Please ask for: Jonny Cooper
Email: jonny.cooper@arun.gov.uk
Telephone: 01903 737532
Our Ref: CM/12/25/PL
Your Ref:
Date: 4th April 2025

Application for Planning Permission

Development: Demolition existing buildings and erection of replacement self / custom build dwelling and garage with associated landscaping. This application may affect the setting of a listed building, is in CIL zone 5 and is CIL liable as a new dwelling.
Location: Rigates Climping Street Climping BN17 5RQ

Drawing
Existing & Proposed
Site Plans

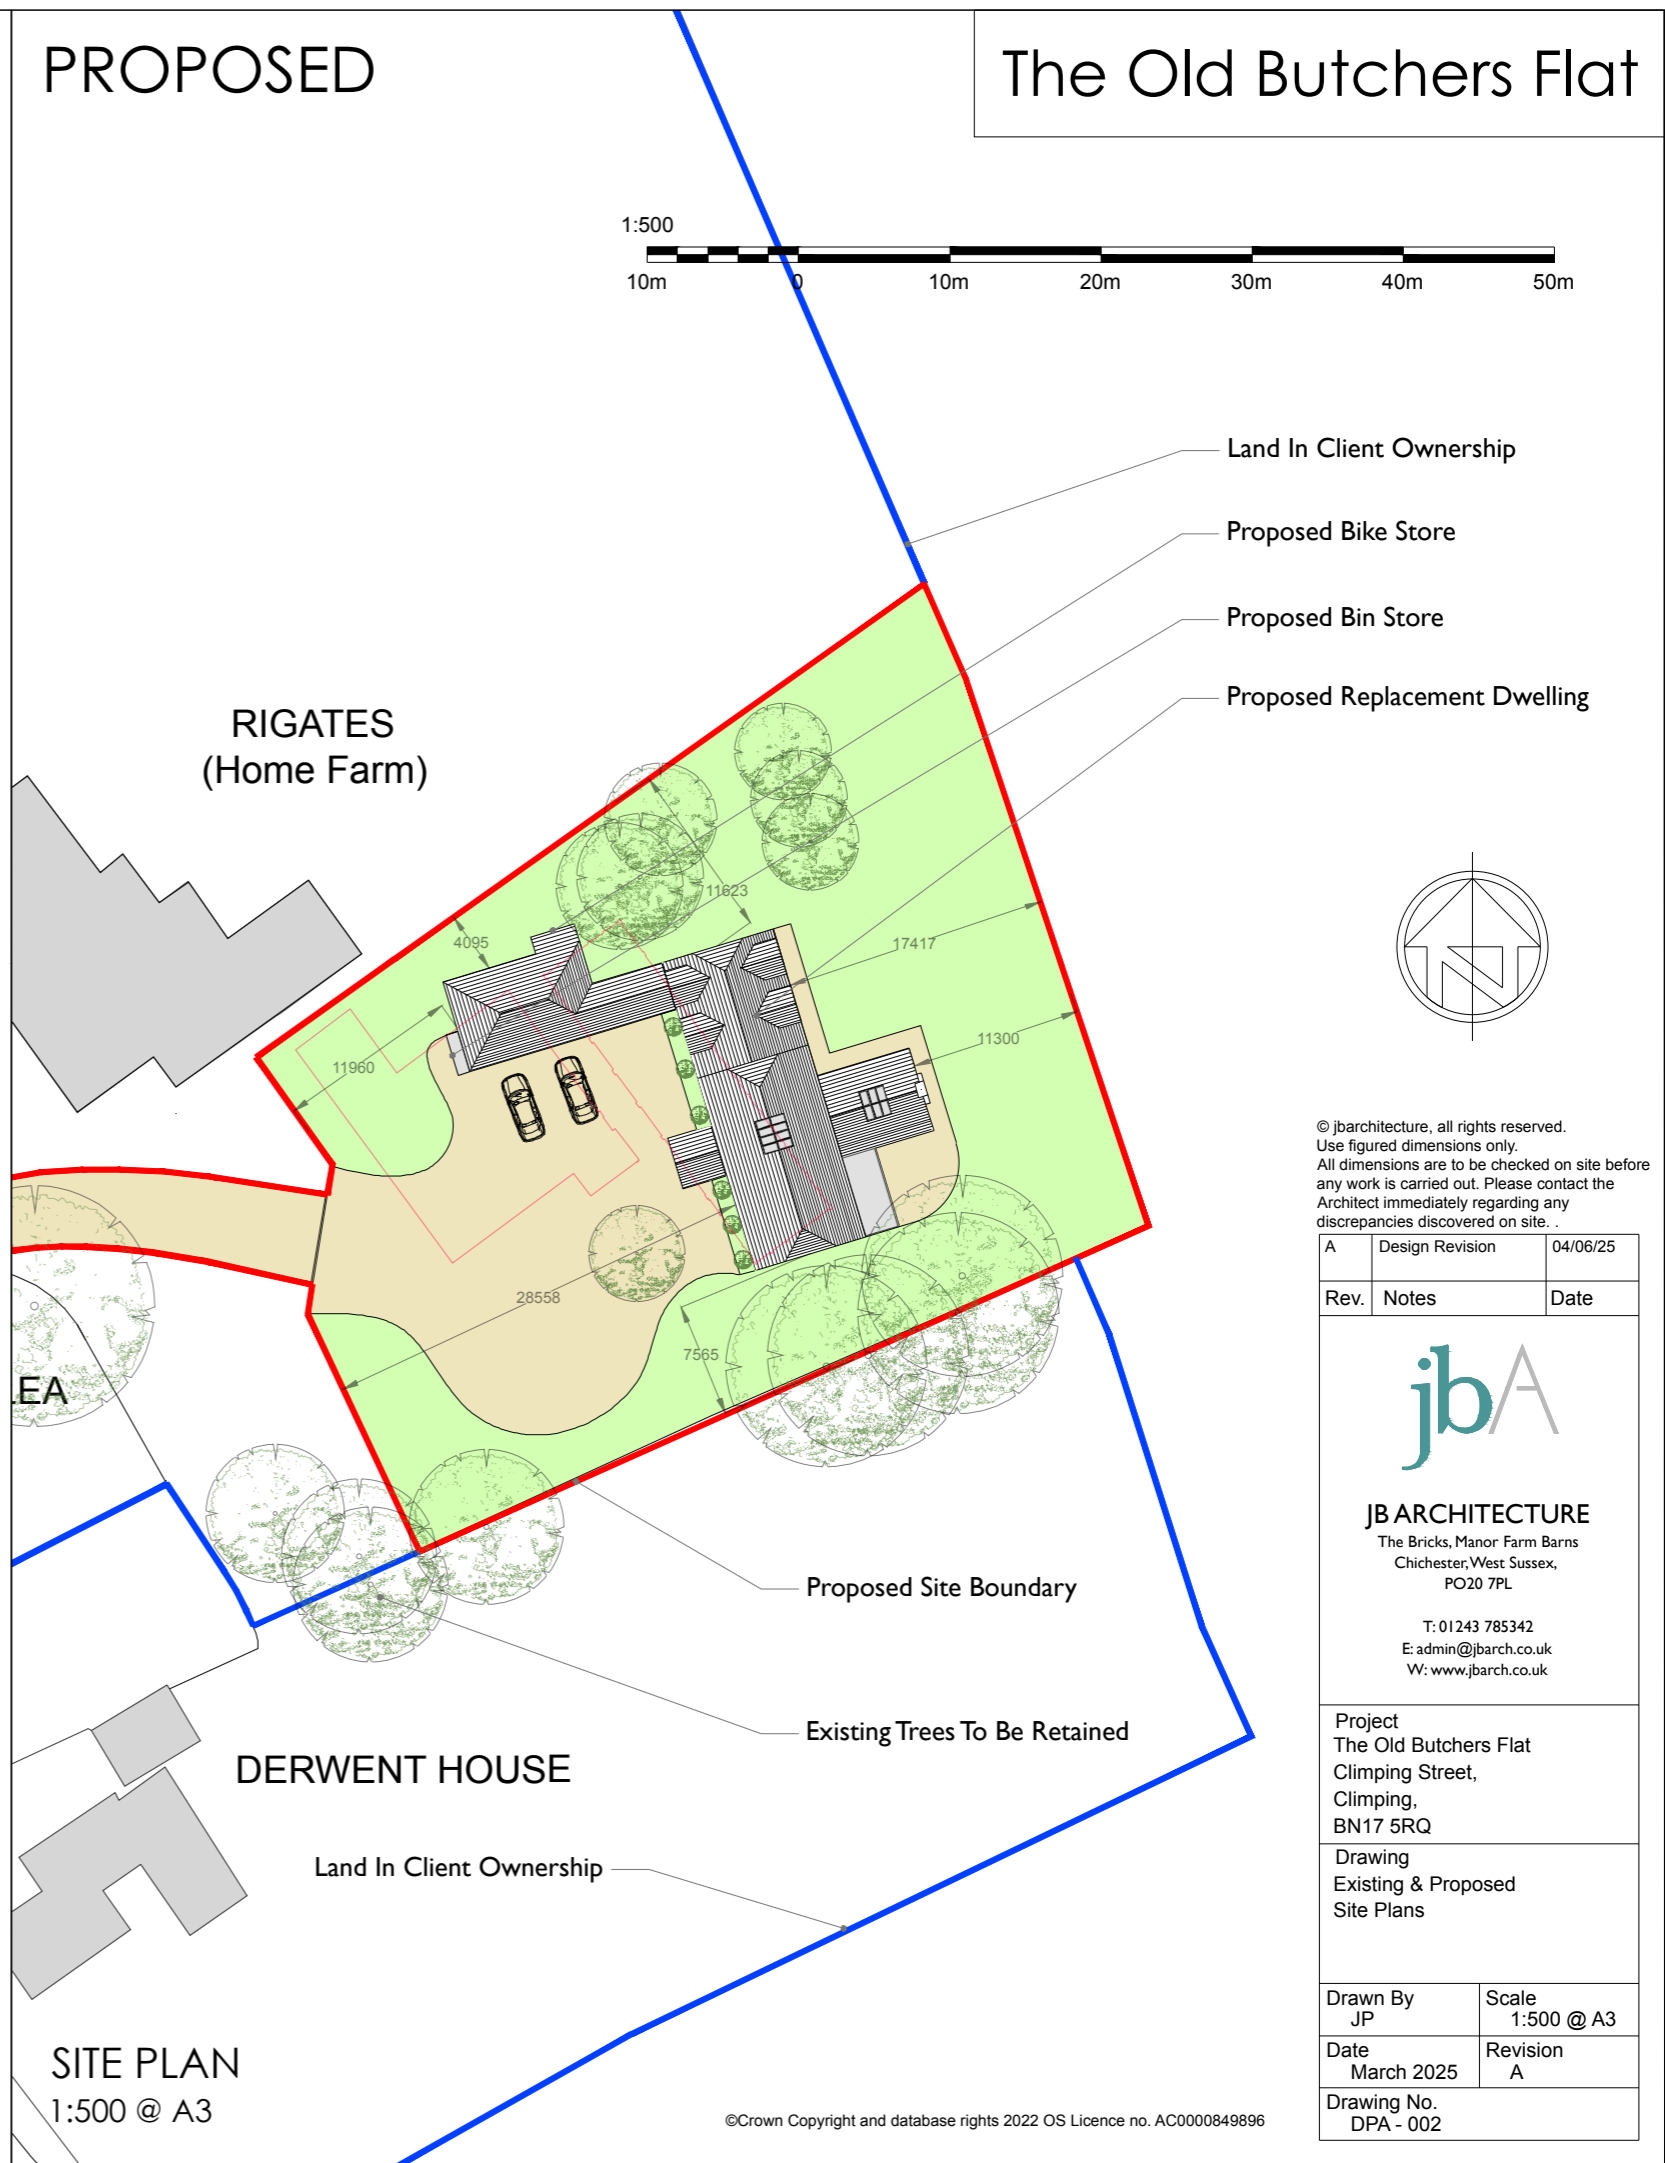
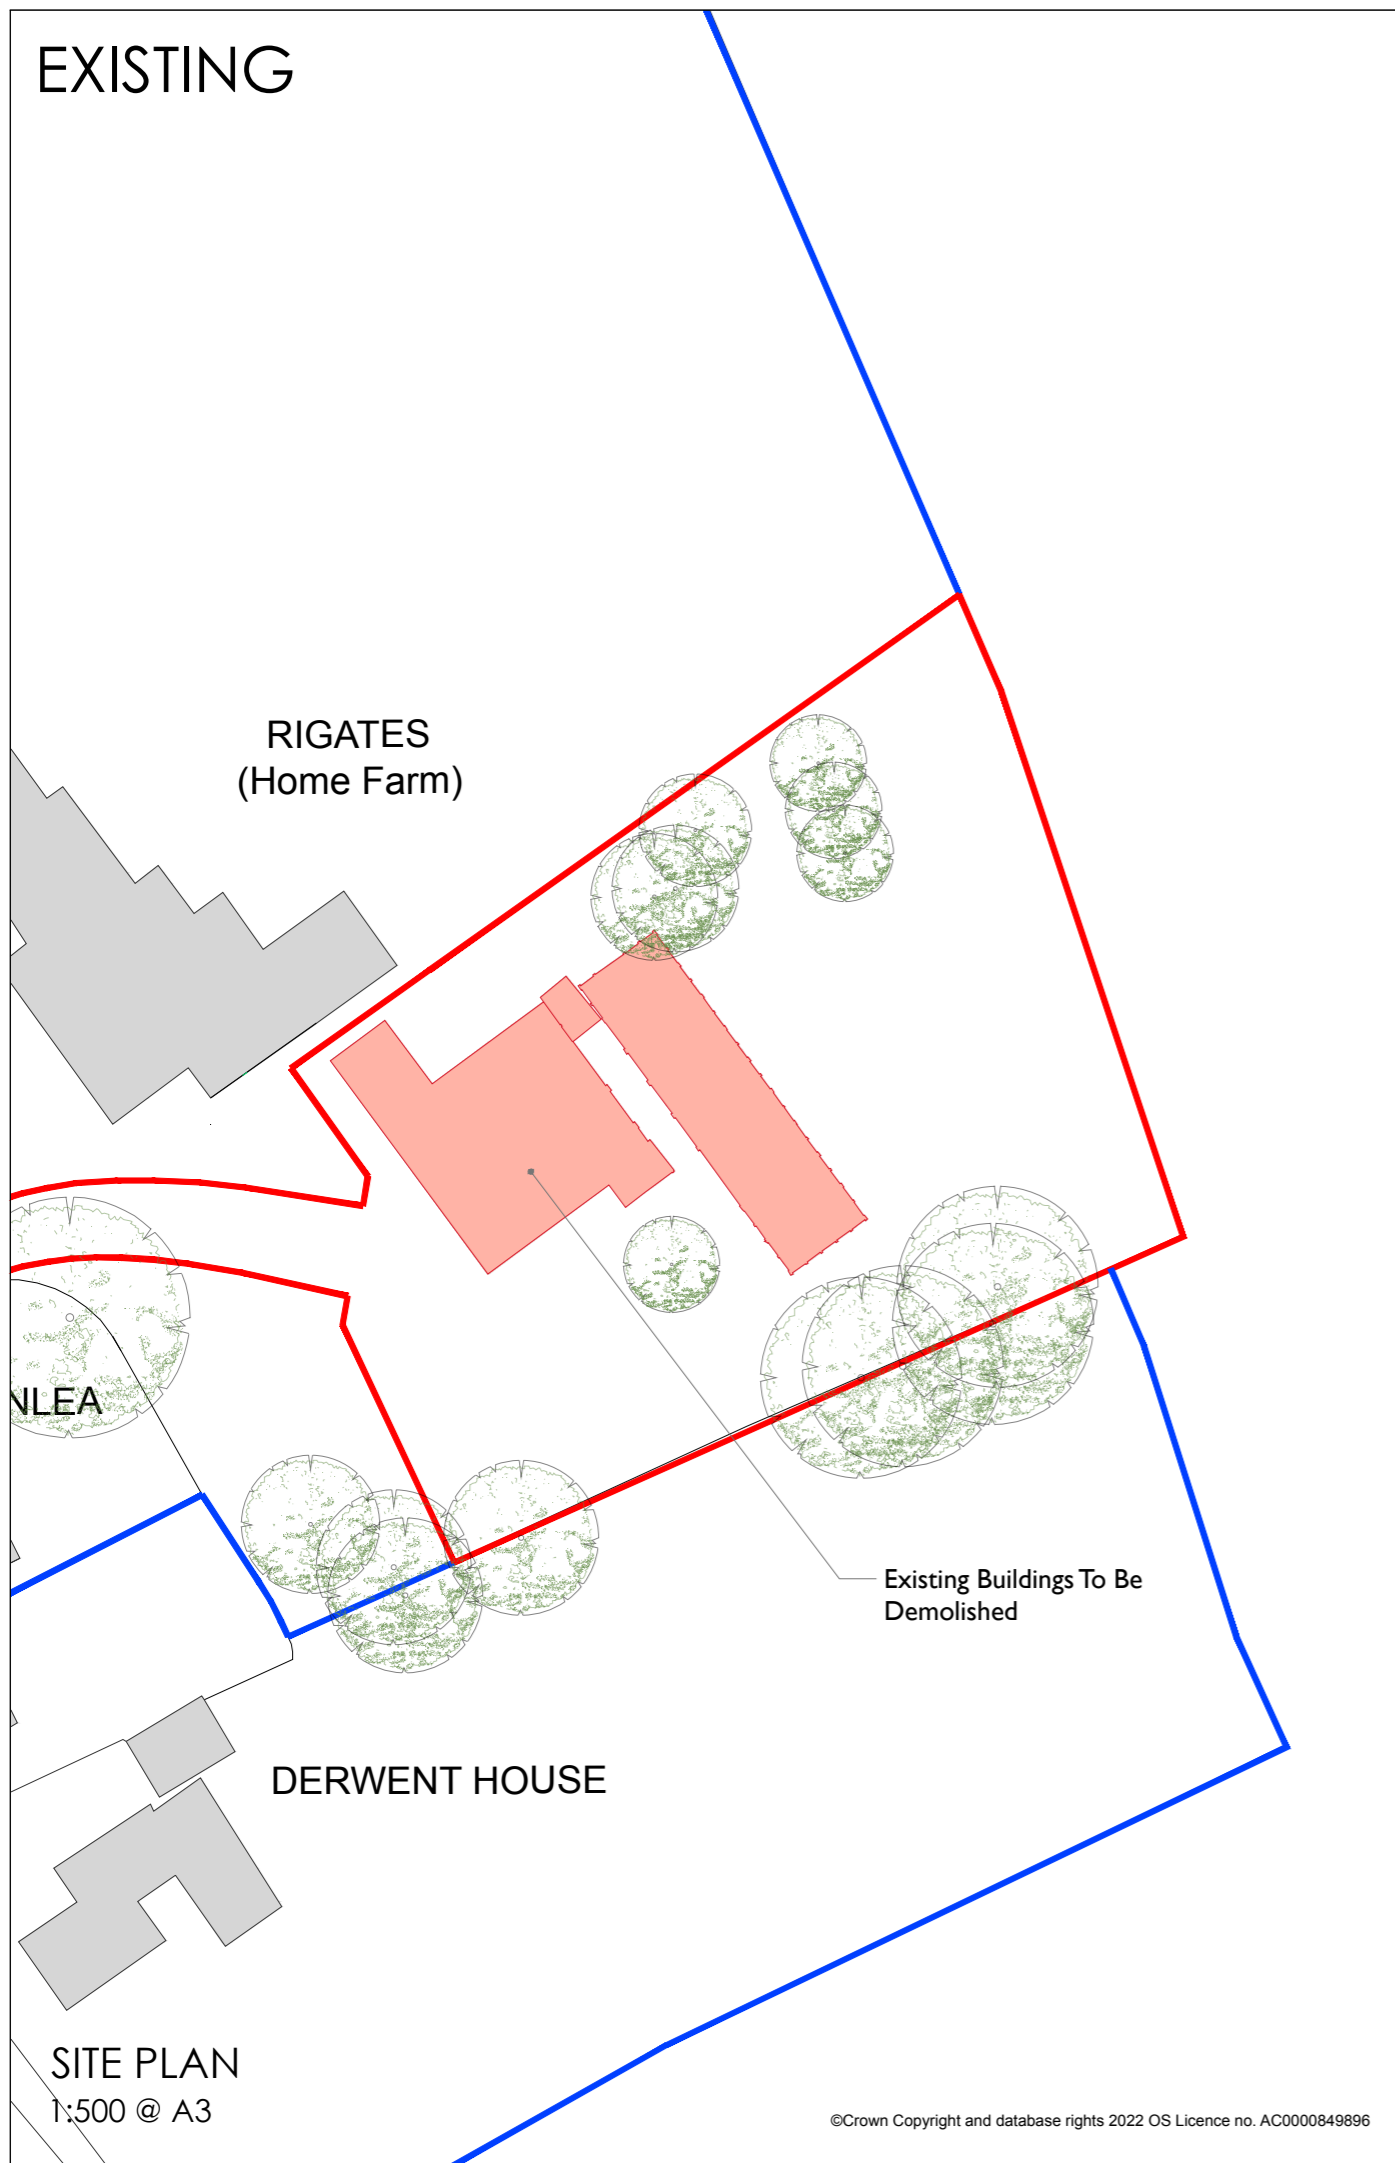
Please amend your proposed site plan (DPA-002) to show the distances from the proposed new dwelling to the site boundaries.

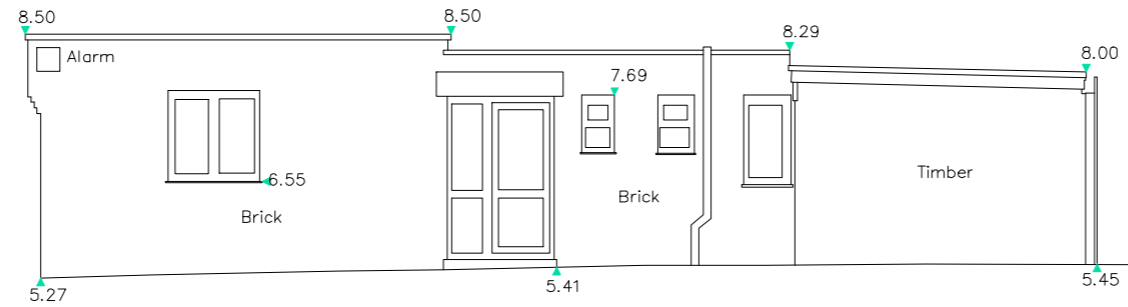
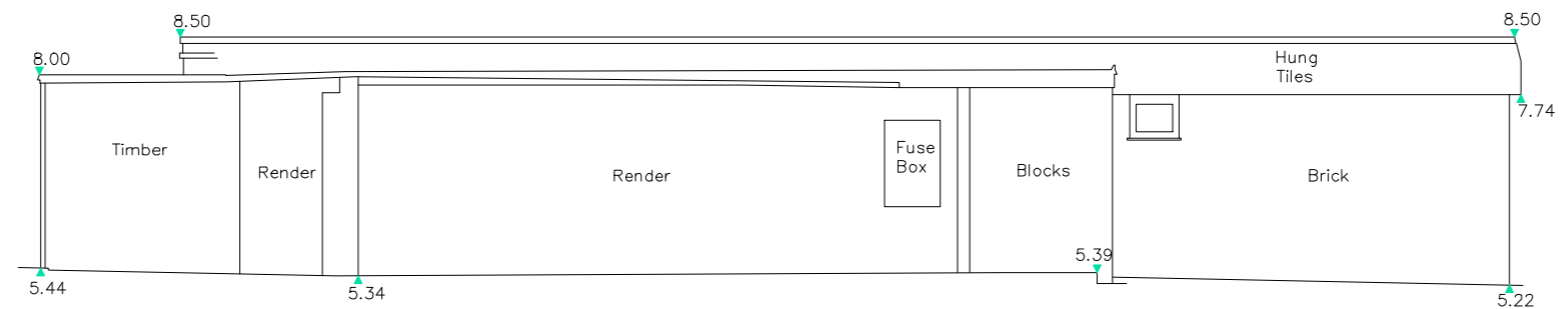
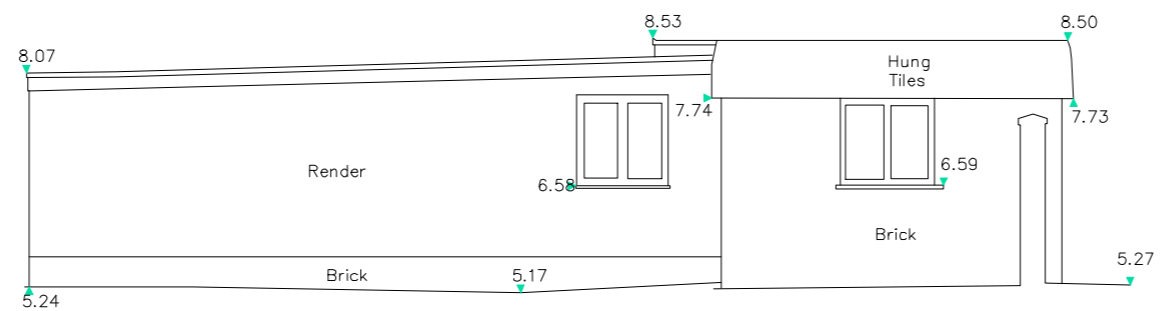
The proposed utility room is missing a door on the north elevation (labelled as the south) and missing a door on the proposed west elevation (the utility room appears to be all in white). Please amend accordingly and resubmit.

The North point on your proposed floor plans is pointing south. This also means that your elevations have been mislabelled. Please amend these accordingly and resubmit.
